WEST SUSSEX COUNTY COUNCIL CONSULTATION

TO:	Arun District Council - FAO: Simon Davis
FROM:	WSCC - Highways Authority
DATE:	5 November 2020
LOCATION:	The Beach Hotel, former Mud Club, Waterloo Square Bognor Regis, PO21 1SU
SUBJECT:	BR/244/20/PL Redevelopment into 11 No. 2 bed apartments & 2 No. commercial units (A1 Retail or A3 Restaurant/Cafe) (resubmission following BR/282/19/PL). This application affects the character & appearance of The Steyne, Bognor Regis Conservation Area & may affect the setting of listed buildings. This site is in CIL Zone 4 (Zero Rated) as flats & other development.
RECOMMENDATION:	More Information

Project Title:	Date:
Waterloo Square, Bognor Regis	06.10.2020
Document Title:	Drawn by / Checked by:
Proposed Site Layout Plan	SR / GG
Drawing Scale / Sheet Size:	Client:
1:500 @ A3	B5 ltd
Drawing Status:	Drawing Number / Revision:
PLANNING	18.103.400

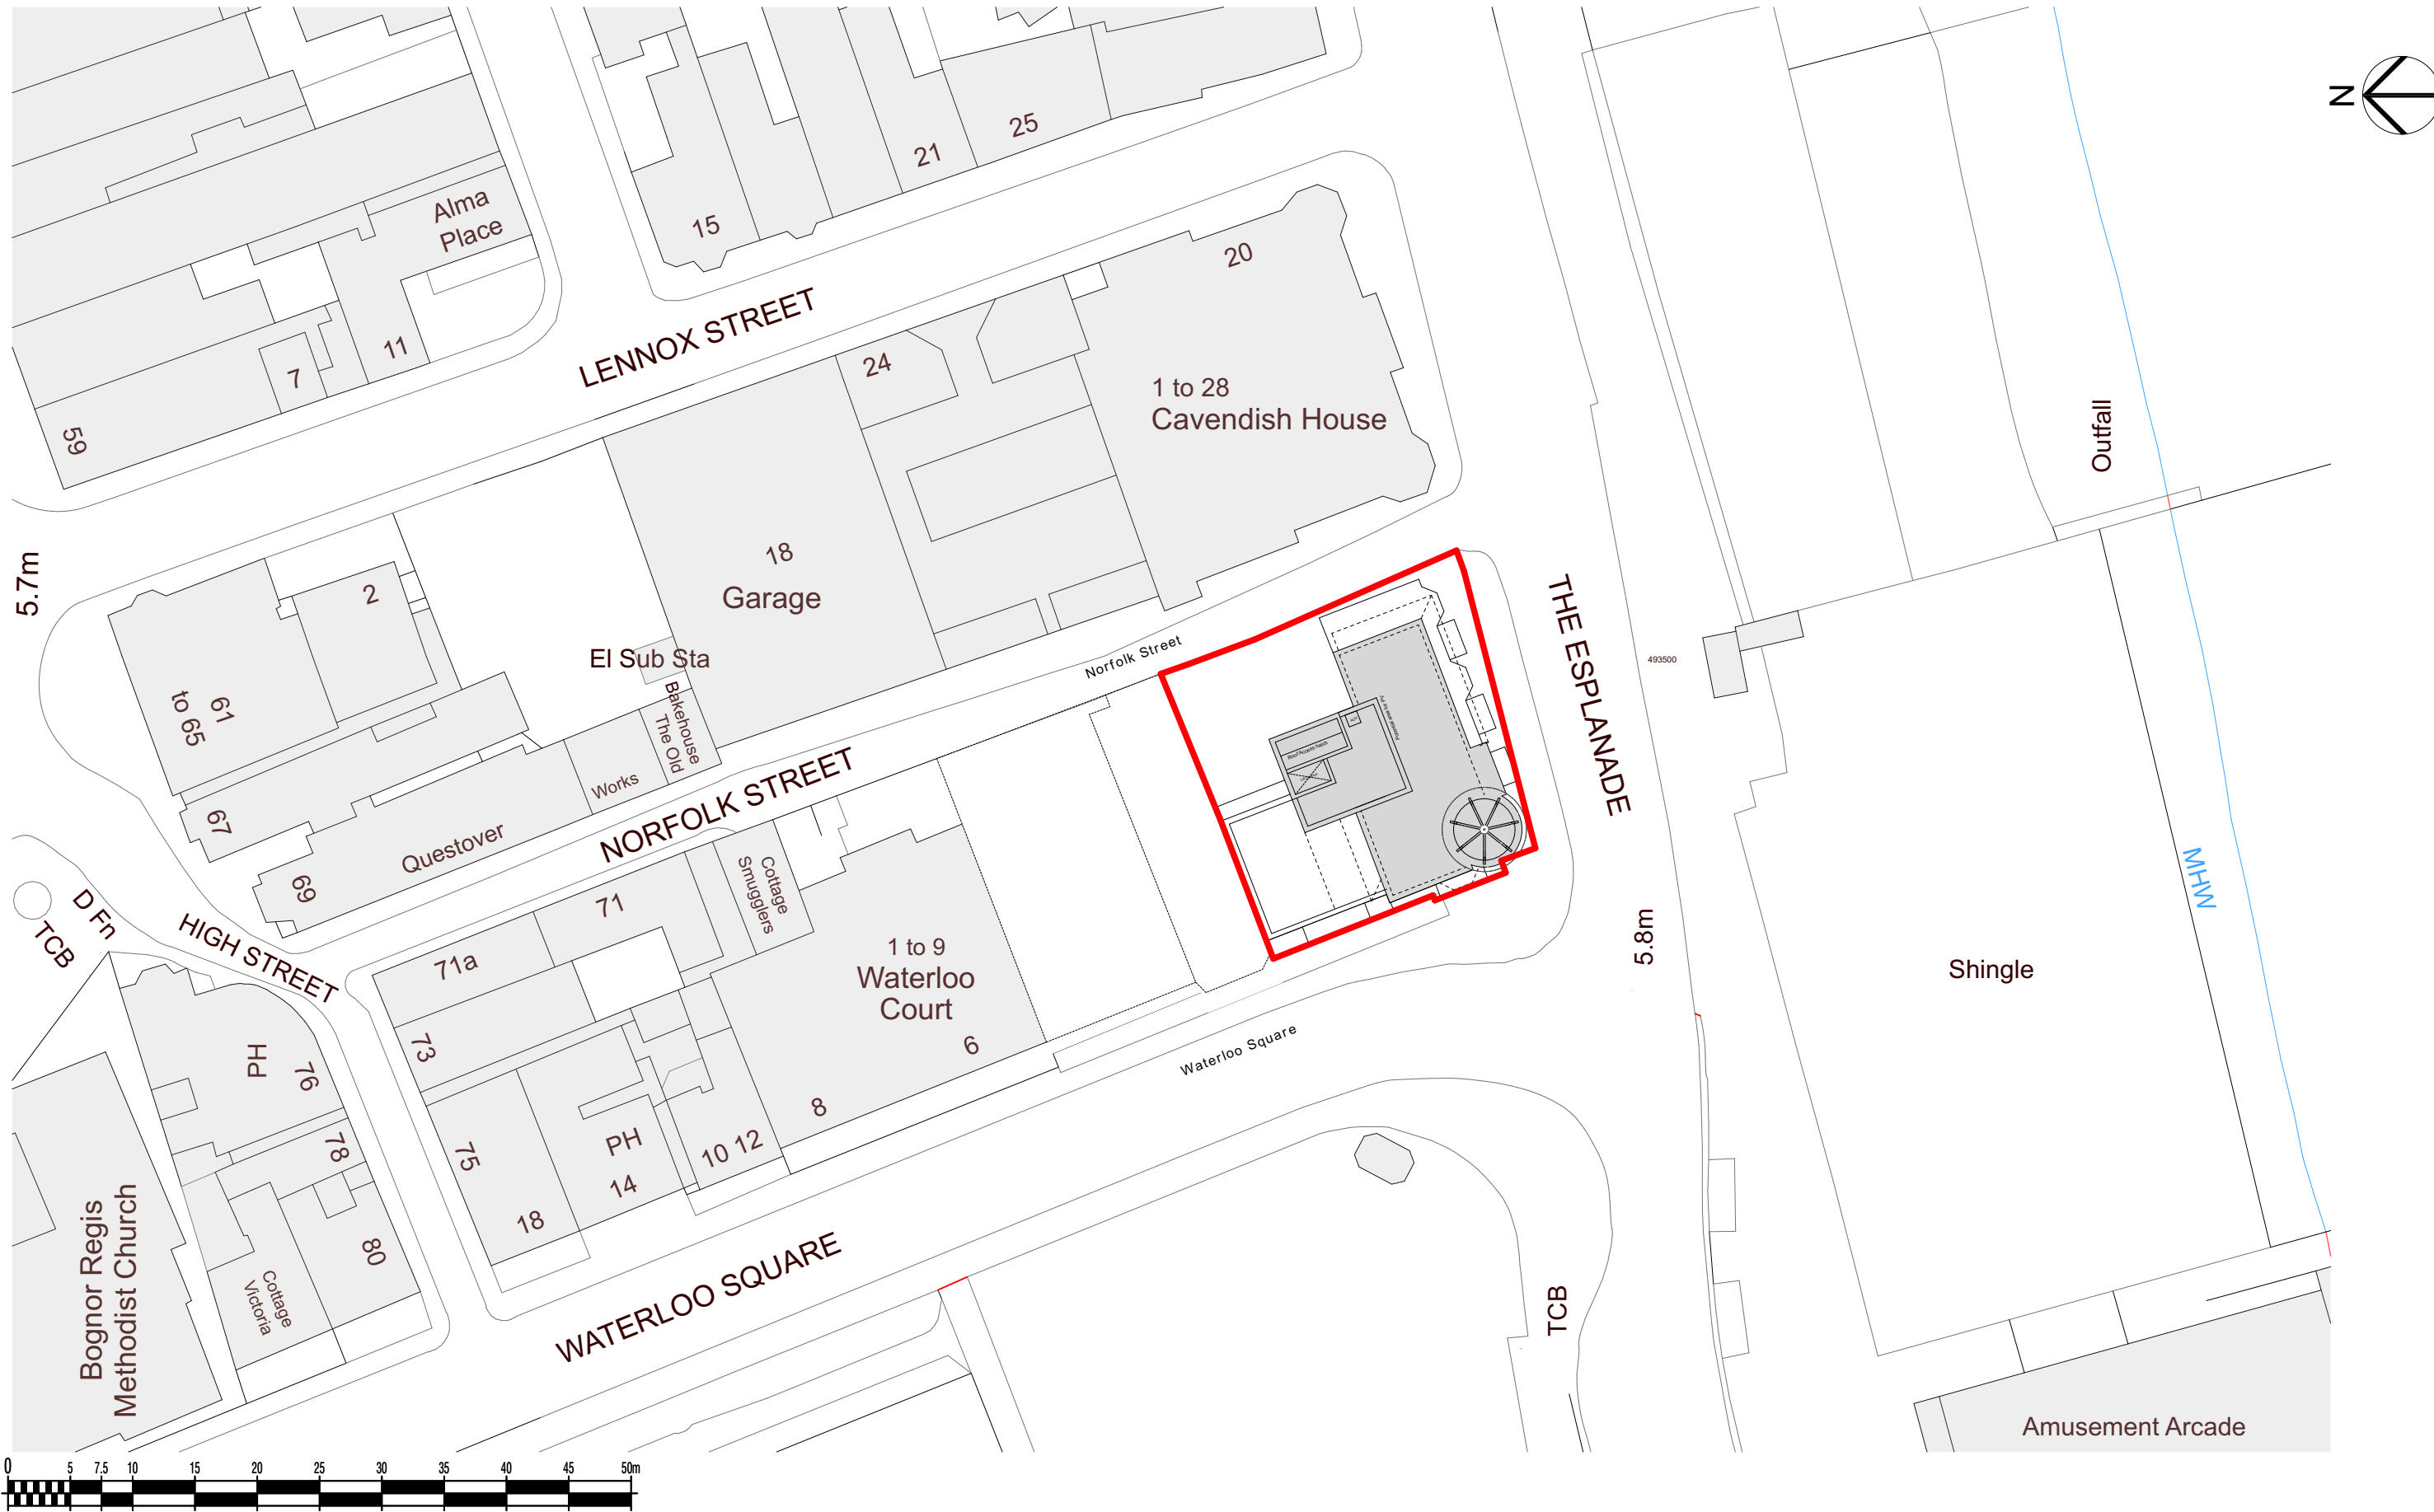
The parking layout has been altered, it should be demonstrated through swept path tracking plans that the spaces are workable. The Loading/Delivery area has been annotated across space 1 and 4. Deliveries in this area may obstruct use of the parking area. Swept path tracking plans should be provided to demonstrate how these altered arrangements are workable for largest service vehicle anticipated.

In summary further information is sought. It is acknowledged that the LHA previously raised no transport grounds to resist the application. Nevertheless, the access, parking and loading/delivery arrangements have altered from BR/292/19 and thus the following information is required:

- New RSA to cover amended access, parking and loading bay arrangements.
- Swept path tracking plans for car parking spaces and loading bay area.
- Consideration to disabled bay/ electric vehicle charging bays.
